Case Number: ACP-323024-25

RE: ACP-323024-25,
For: Proposed elevation of local tertiary road (L-52214)
At: Cuan Na Loinge, Ceantar na nOileán, Conamara, Co. Galway
FAO: An Coimisiún Pleanála
Ref: 24155-LT-2201-FL01

An Coimisiún Pleanála shared three submissions regarding the above application on 9th September 2025 with LCE. The correspondence also invited the applicant to make a submission on the observations received from the following three organisations:

**PROPOSED SITE LAYOUT PLAN
 SAC EXTENTS**
 SCALE 1:500

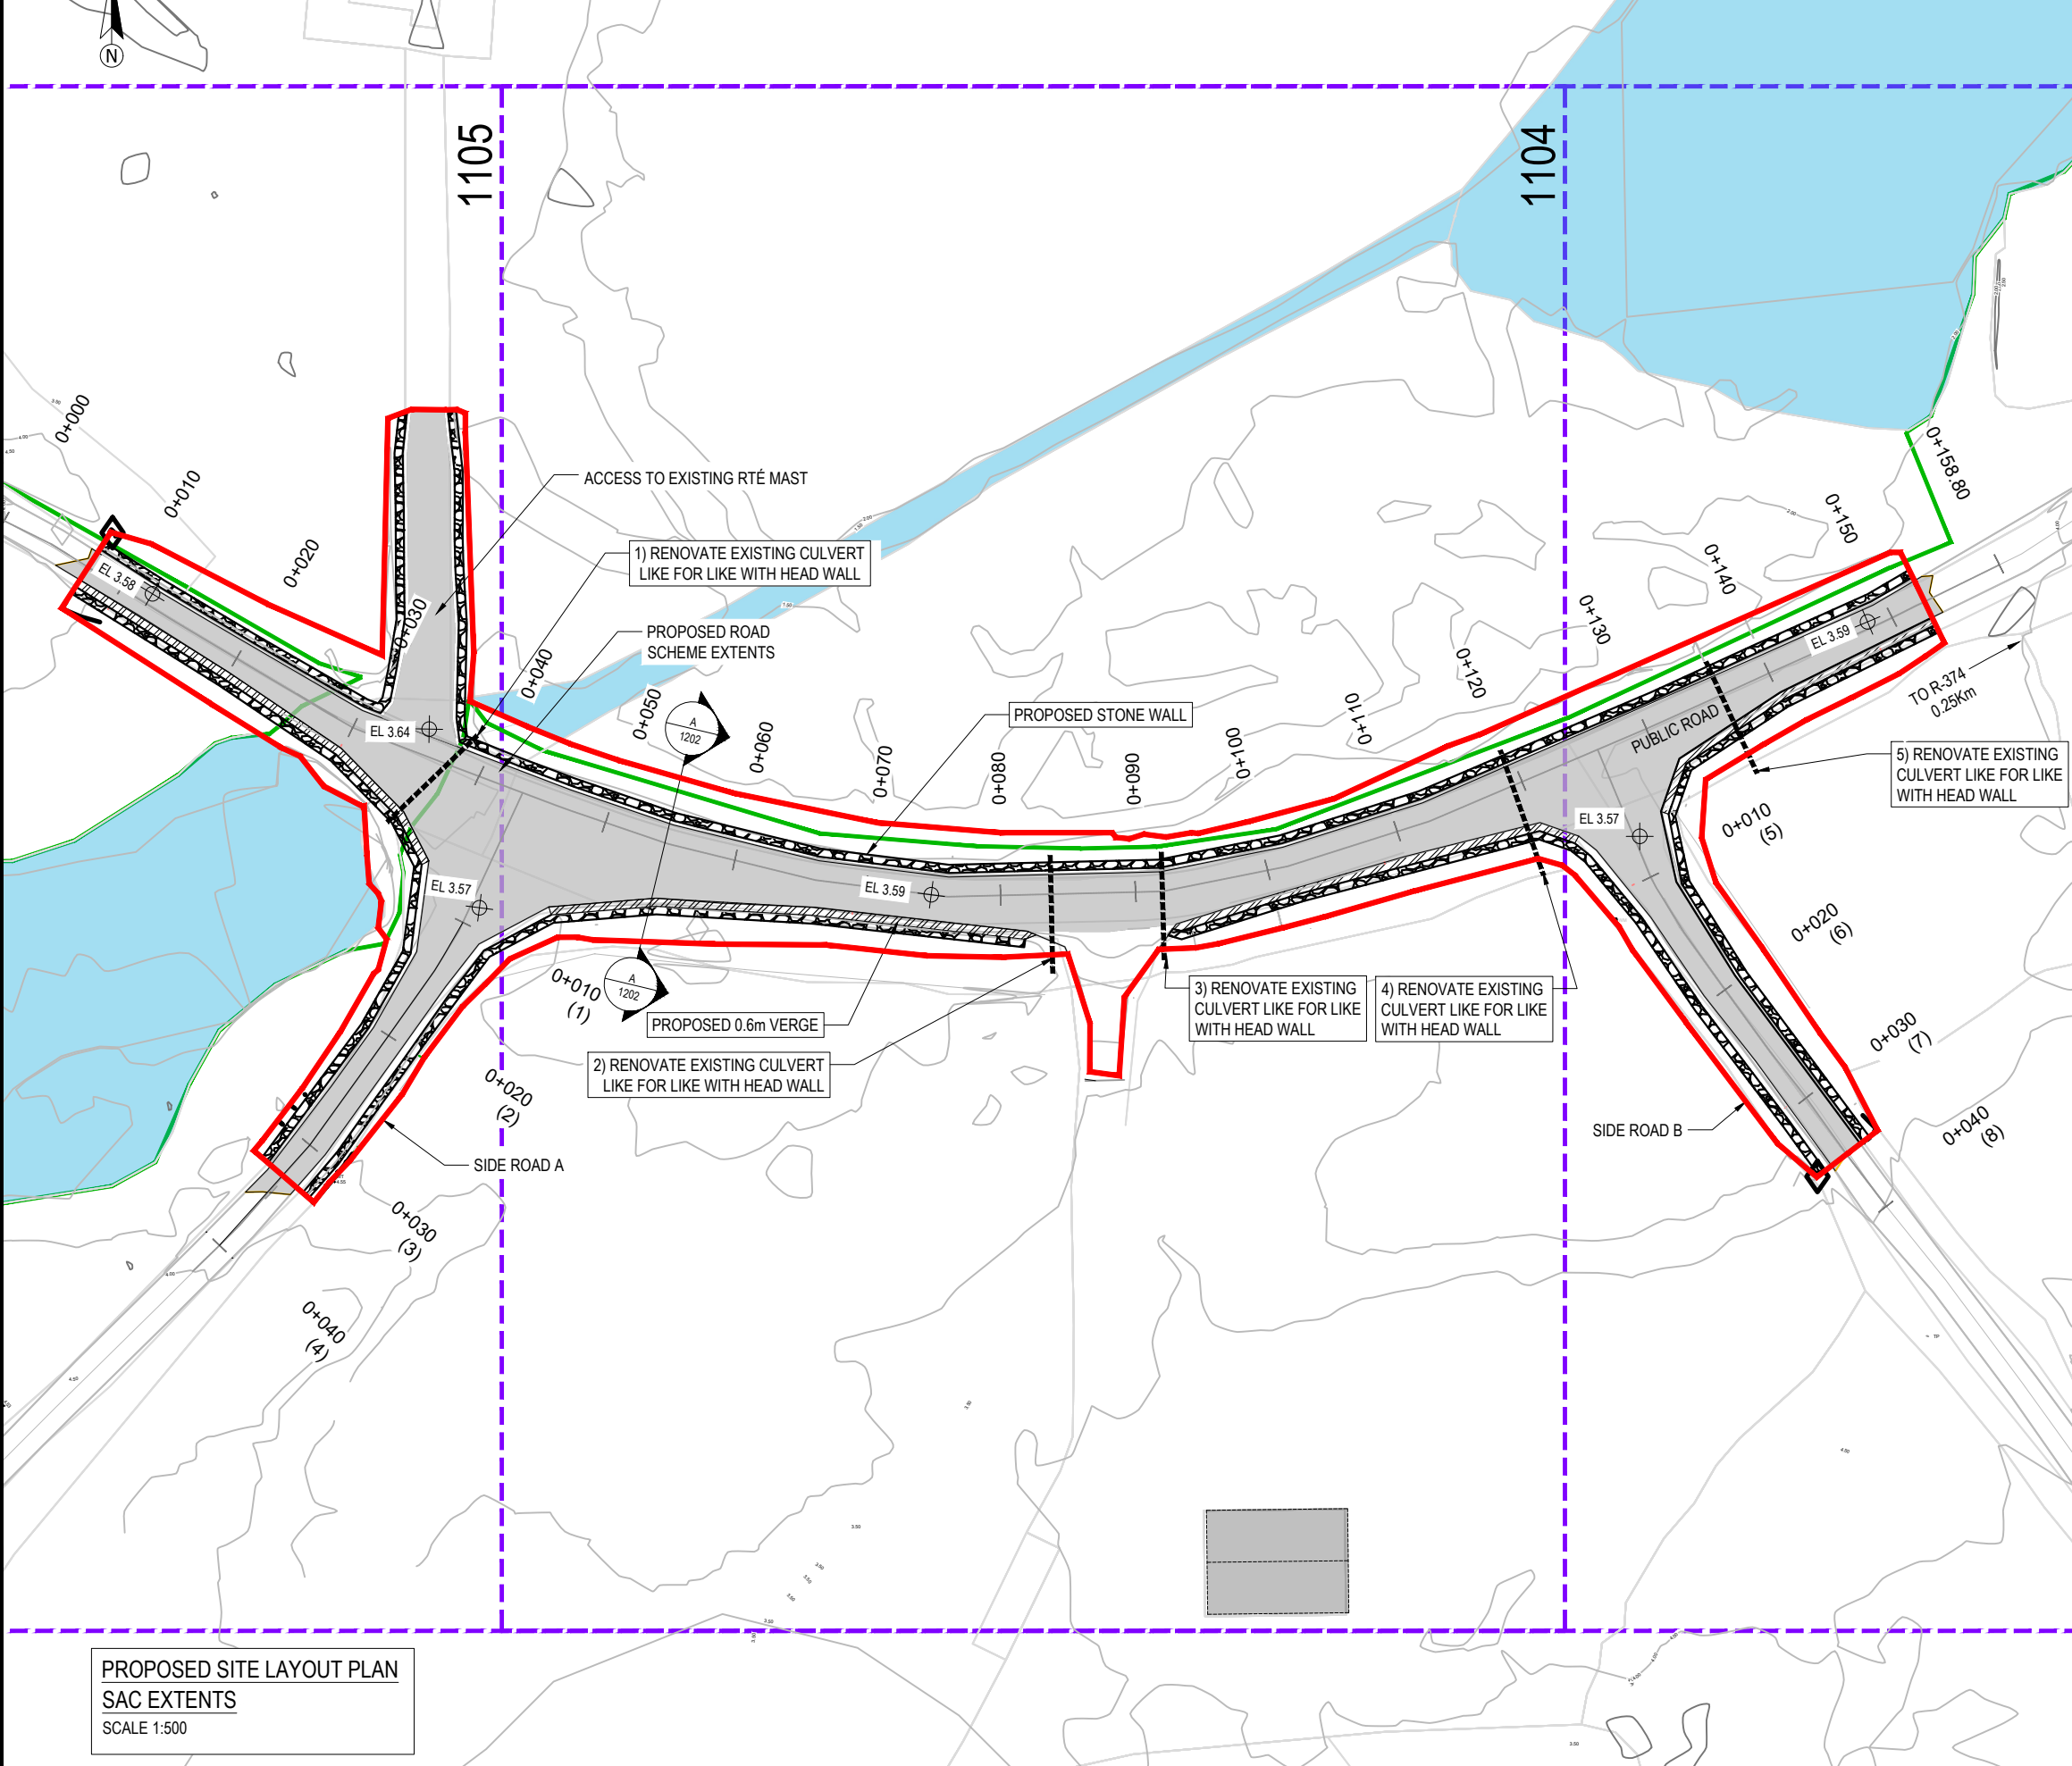
Submission text: “The Department notes that the application site borders the Kilkieran Bay Islands Special Area of Conservation (SAC) (Site Code: 002111). Immediately adjacent to the northern side of the proposed works there are two Annex I habitats, Coastal lagoons [1150] and Atlantic salt meadows (*Glauco-Puccinellietalia maritima*) [1330], for which this SAC is designated. The Department notes that the Natura Impact Statement (NIS) provided with the application does not identify that an area of the Annex I habitat Coastal Lagoon occurs immediately adjoining the proposed works (as outlined in Map 4 of NPWS, 2014¹). The NIS also states that there will be no direct loss of habitat within the SAC as a result of the proposed works, however, the cross-sectional diagram re-produced in the document ‘Preferred scheme option report’ indicated that the rock armour, which will occur along the elevated road, will be significantly wider than the existing road. Consequently, there is some uncertainty as to whether the area of Coastal Lagoons [1150], or Atlantic salt meadows (*Glauco-Puccinellietalia maritima*) [1330], will be subject to a loss of area as a result of the proposed development. The Department recommends that An Coimisiún Pleanála is satisfied that they have sufficient information to determine that the proposed works, including rock armour, do not extend into any areas that correspond to either the Annex I habitat Coastal lagoons [1150], or the Annex I habitat salt meadows (*Glauco-Puccinellietalia maritima*) [1330]. It is a Conservation Objective for both within the Kilkieran Bay and Islands SAC that there are be stable or increasing².”

The Coastal Lagoon habitat is identified in the NIS submitted as part of the application. Table 6.1, states that the SAC lies immediately adjacent the site, and Table 9.2, identifies three NIS habitat types (Coastal lagoons, Atlantic salt meadows and Mediterranean salt meadows) and states that “These habitats have hydrological connectivity to the site, as such the SSCOs of this habitat will be considered in detail and mitigation measures outlined to protect this habitat.”

The Coastal lagoon within the SAC has an area of 122.8ha (1,228,000 m²). The scheme proposes to replace existing wall and boundary structures like for like slightly offset from their original positions. The footprint of the boundary works element is approximately 150 m².
